Cottam Solar Project

Schedule of Changes (Deadline 5)

PINS Reference: EN010133

Document Reference: EX5/C8.1.7_D

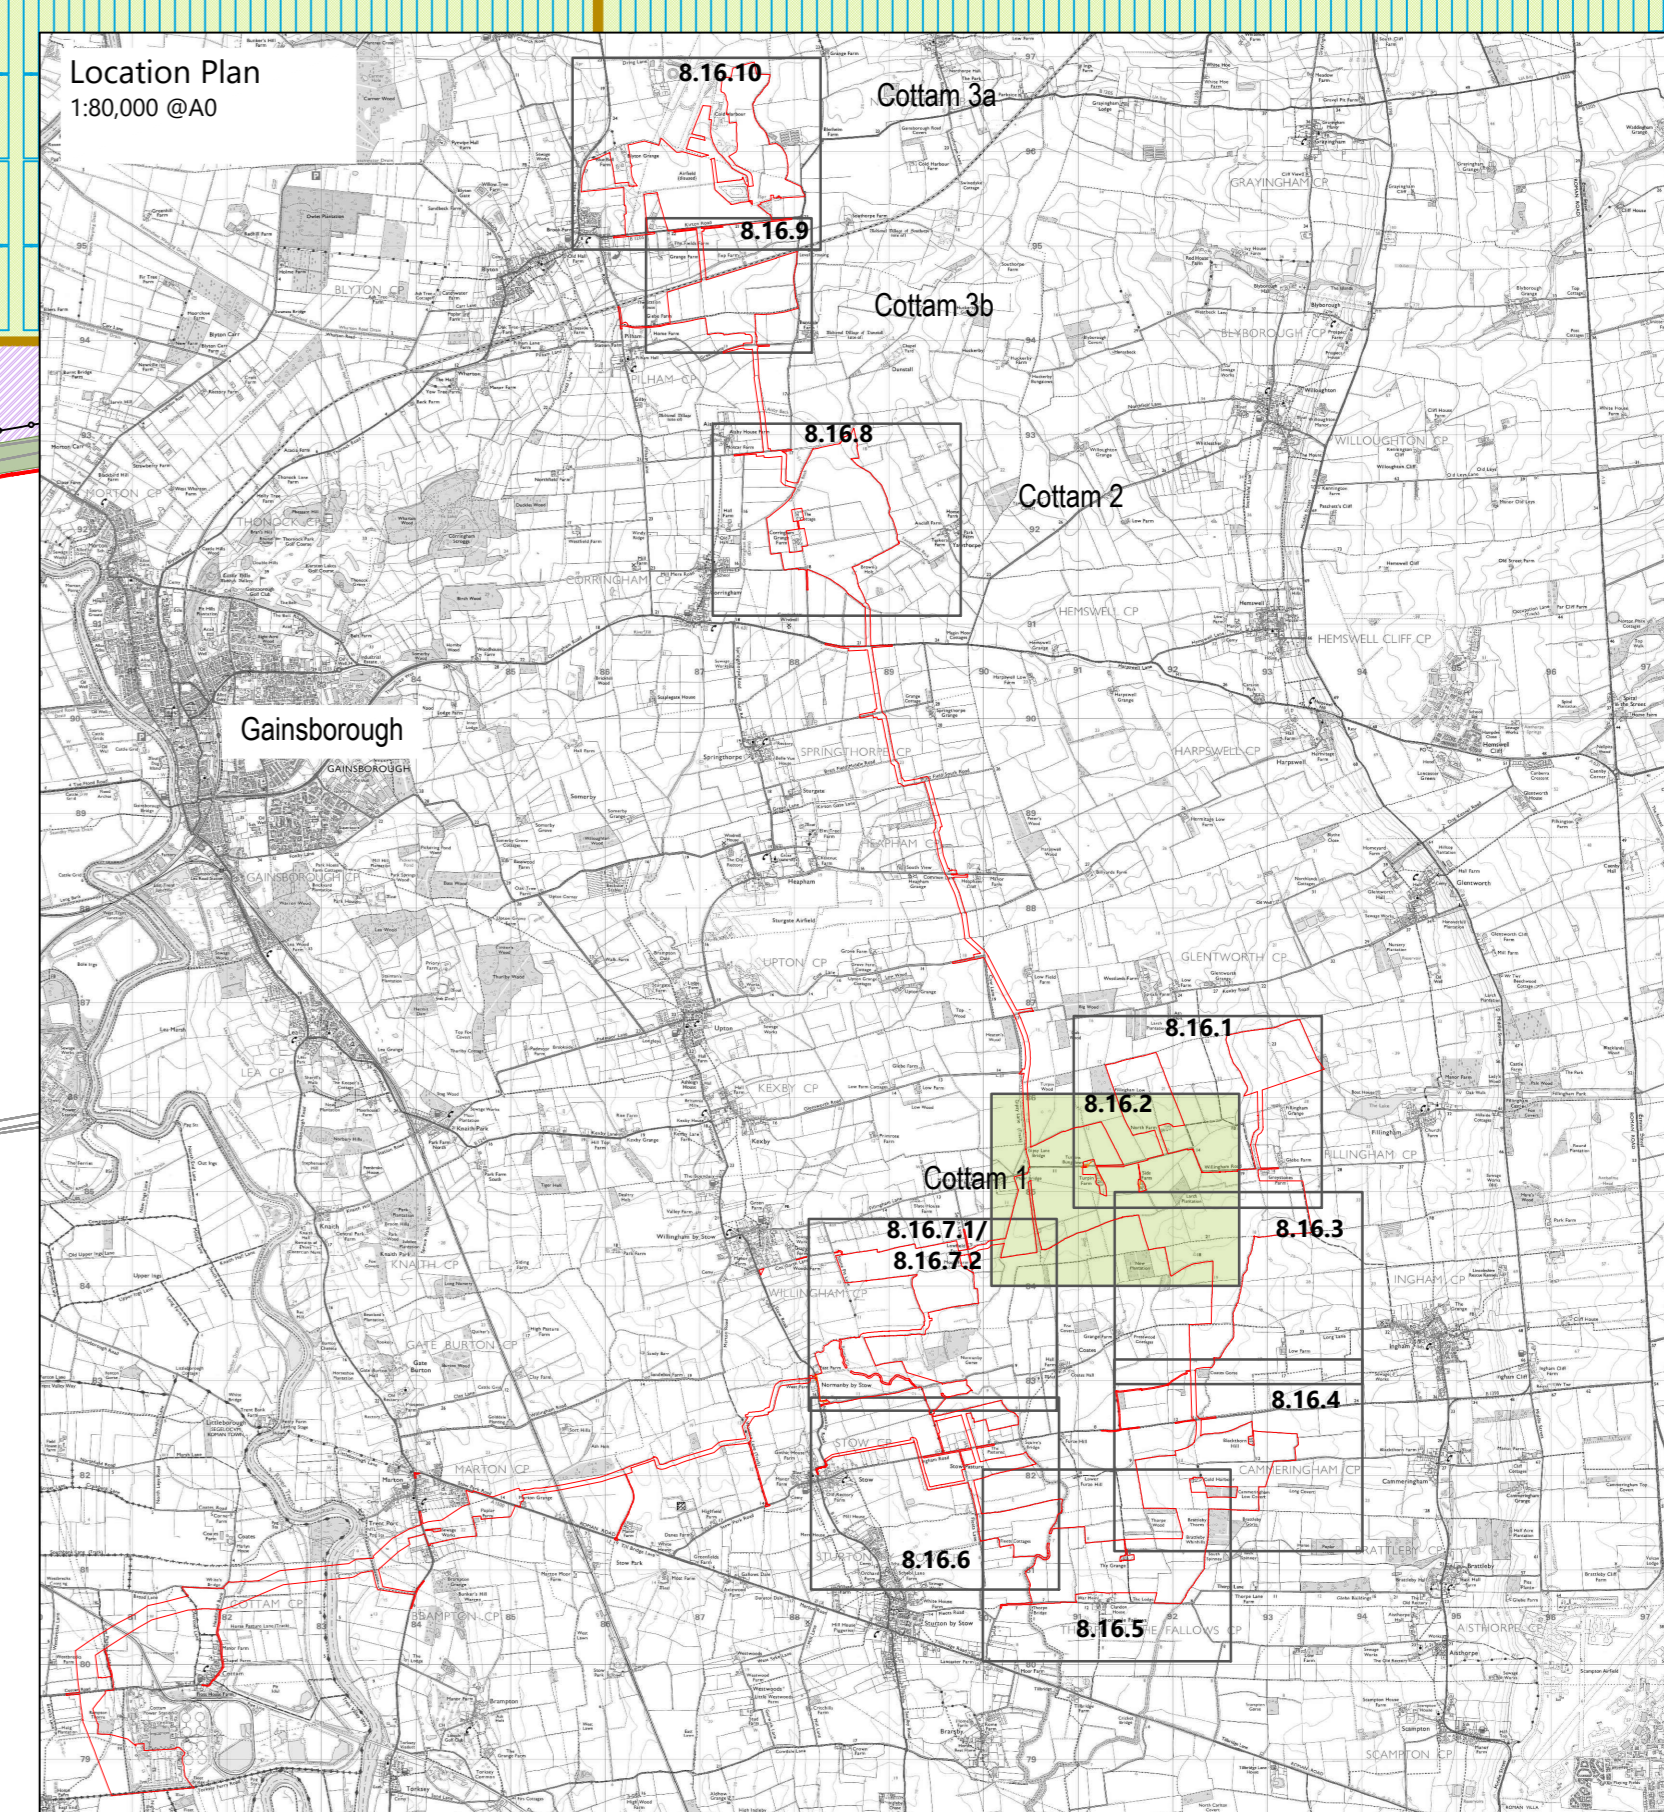
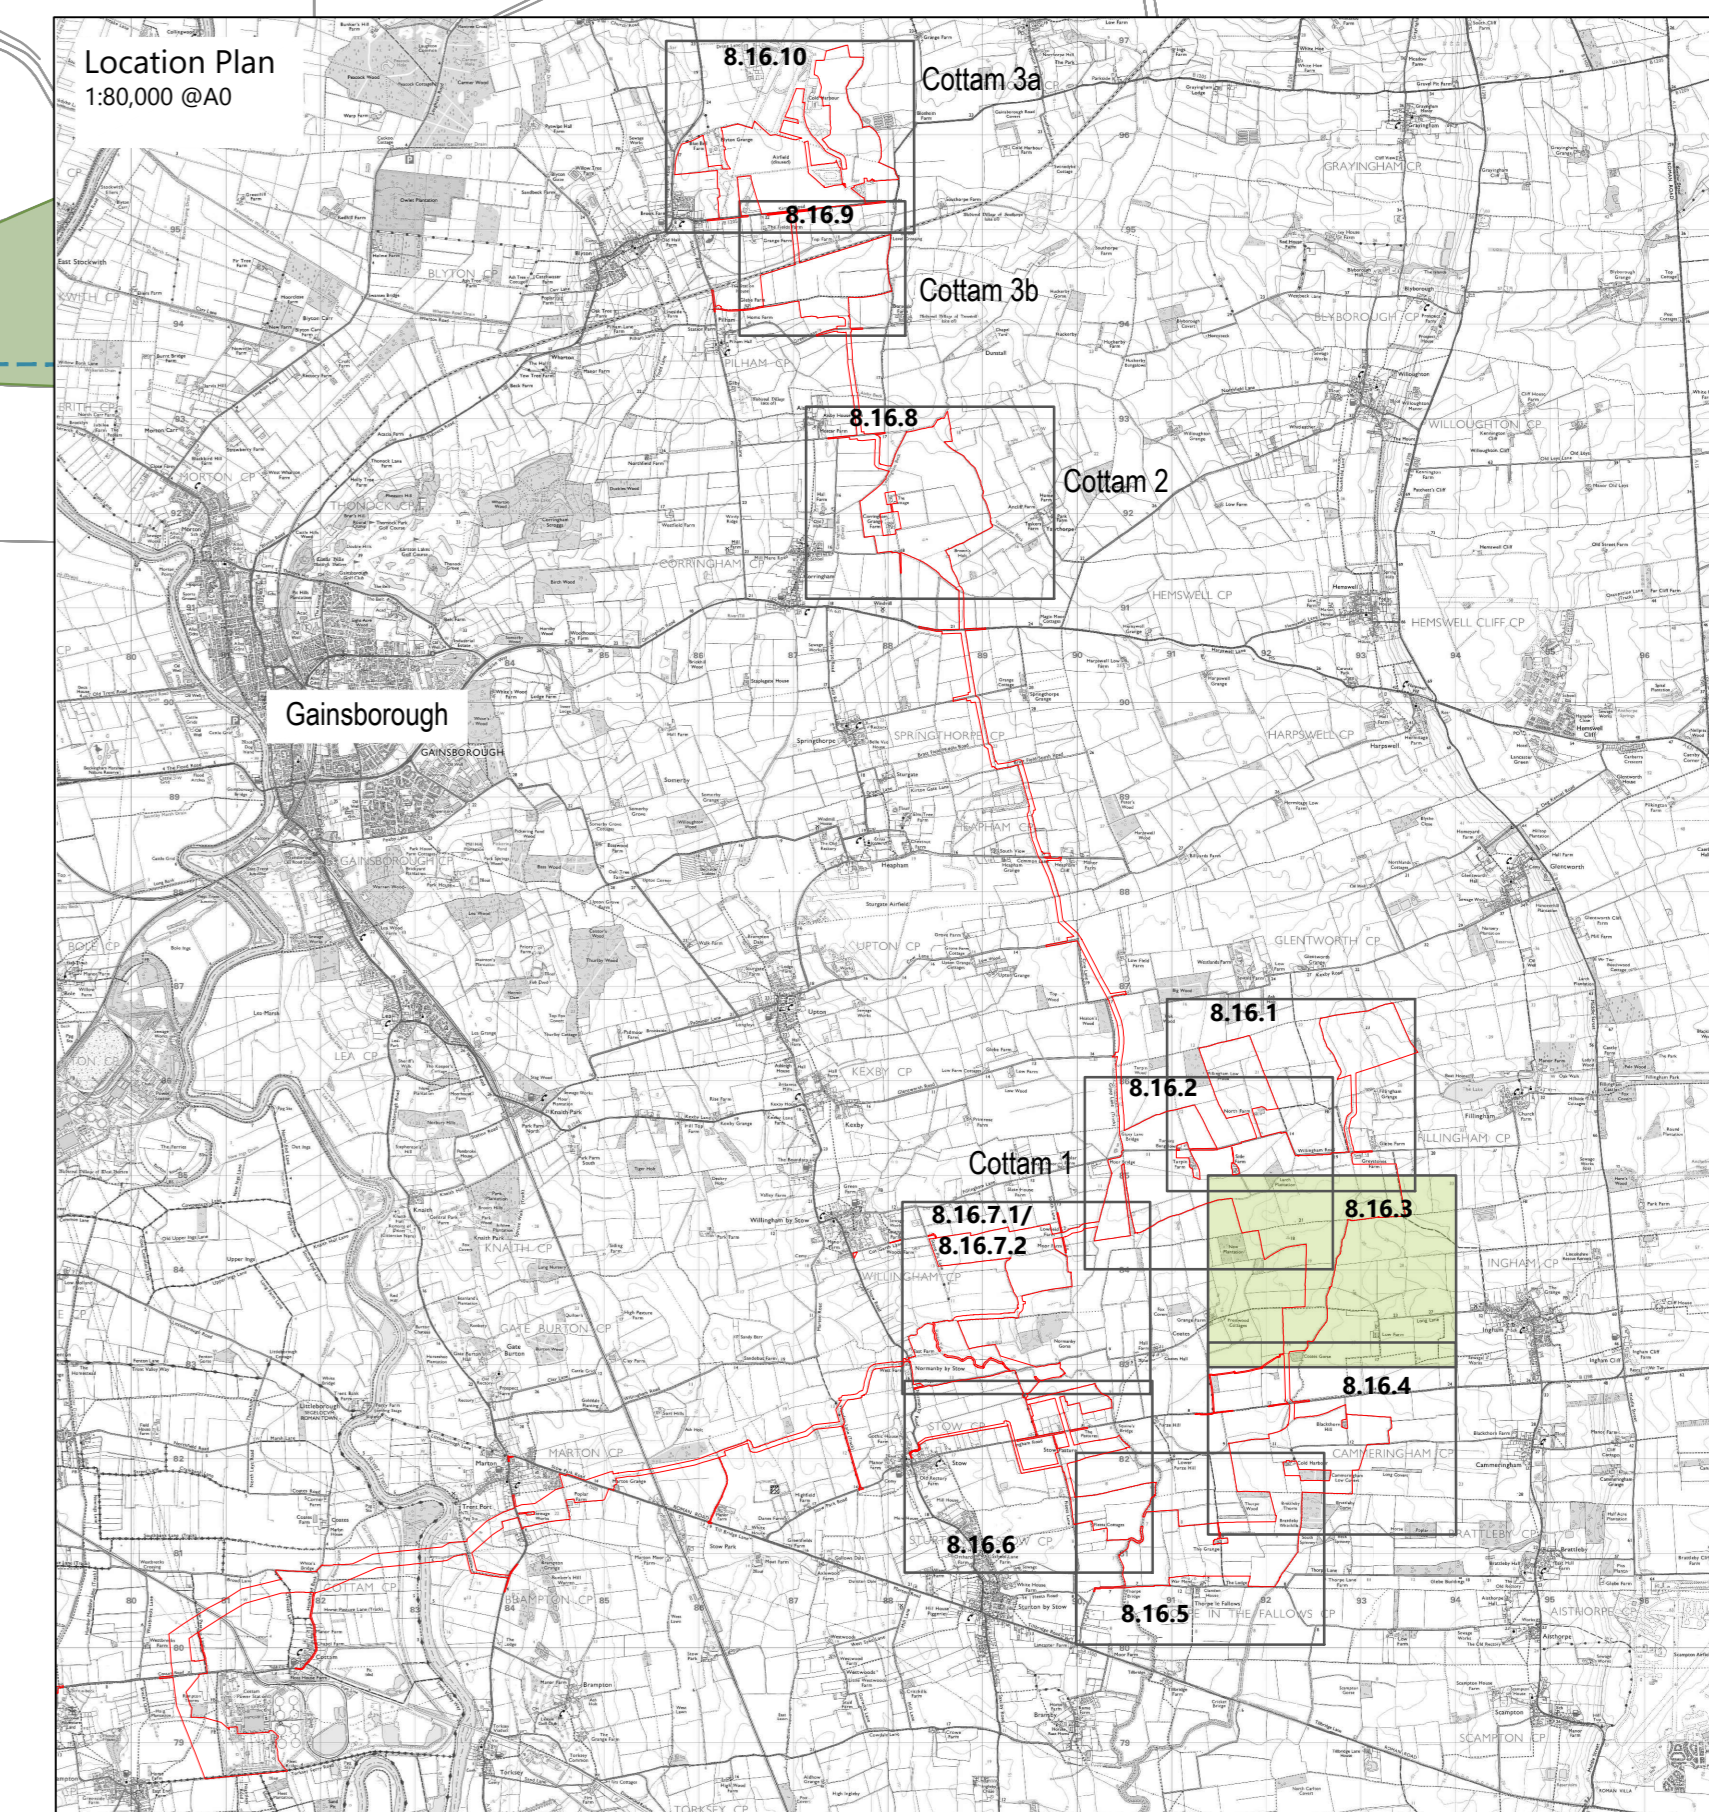
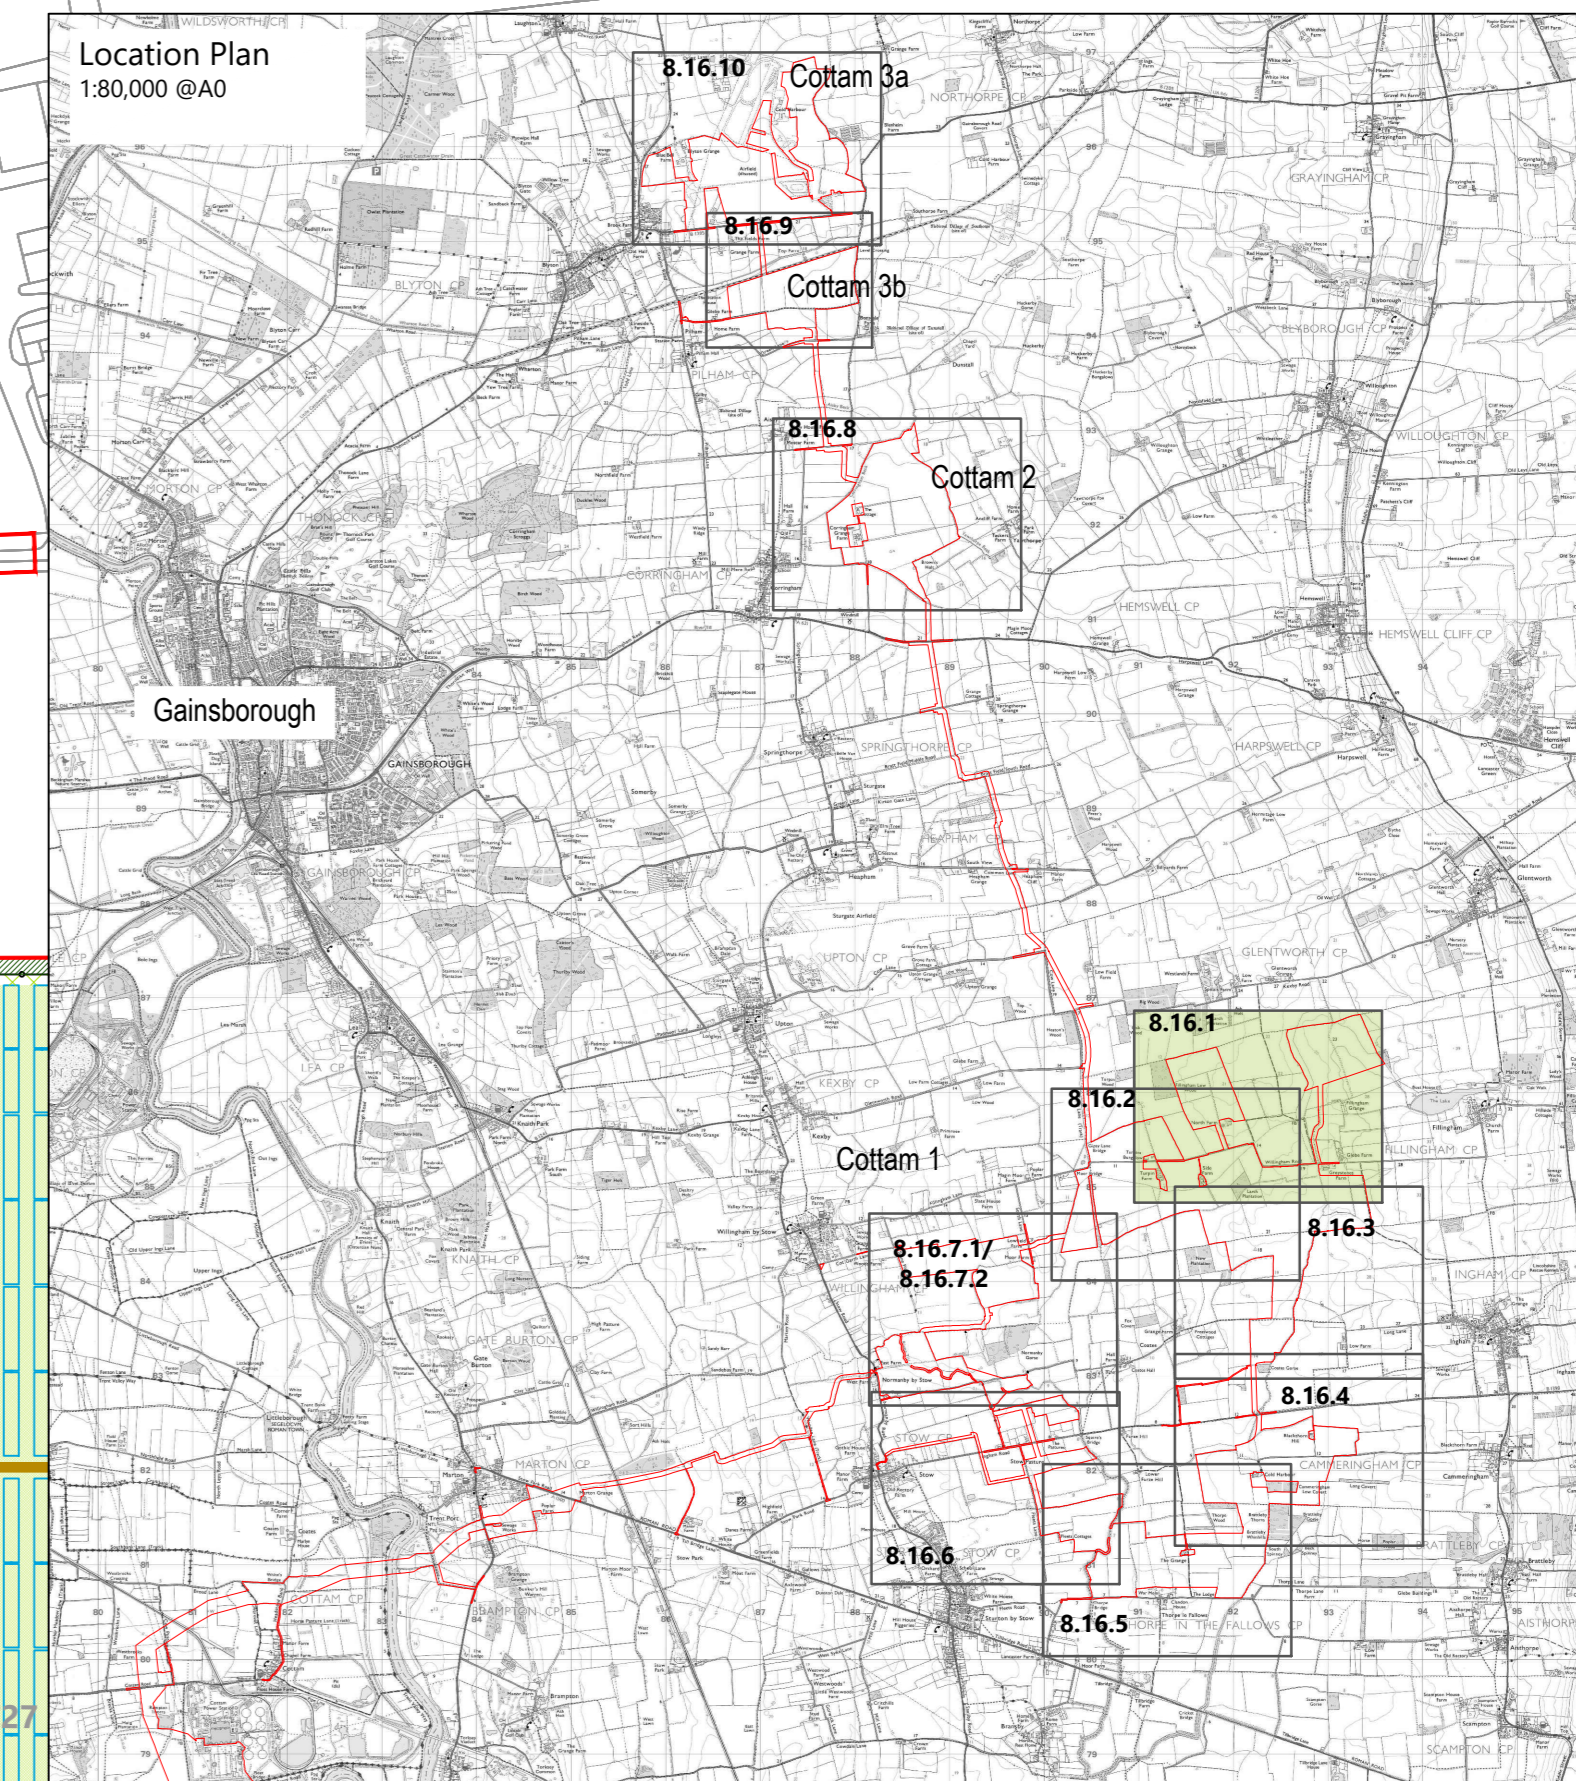
C6.4.8.16.1 to C6.4.8.16.10 Landscape and Ecology Mitigation and Enhancement Plans	[APP-305 to APP-315]	Revision A [EX1/ C6.4.8.16.1_A to EX1/ C6.4.8.16.10_A]	Deadline 1 17 October 2023	Correction of typos, to show additional hedgerows to be removed and to provide clarity of IDB Drain locations.	Minor editorial changes for clarity.
C6.5 ES Non-Technical Summary	[APP-336]	Revision A [EX1/C6.5_A]	Deadline 1 17 October 2023	Paragraphs 6.3.14 to 6.3.16, and 6.3.20 to 6.3.21, updated clarifying as to which part of the Site, and which assessment period the effects relate to.	To provide clarity and consistency and minor editorial changes.
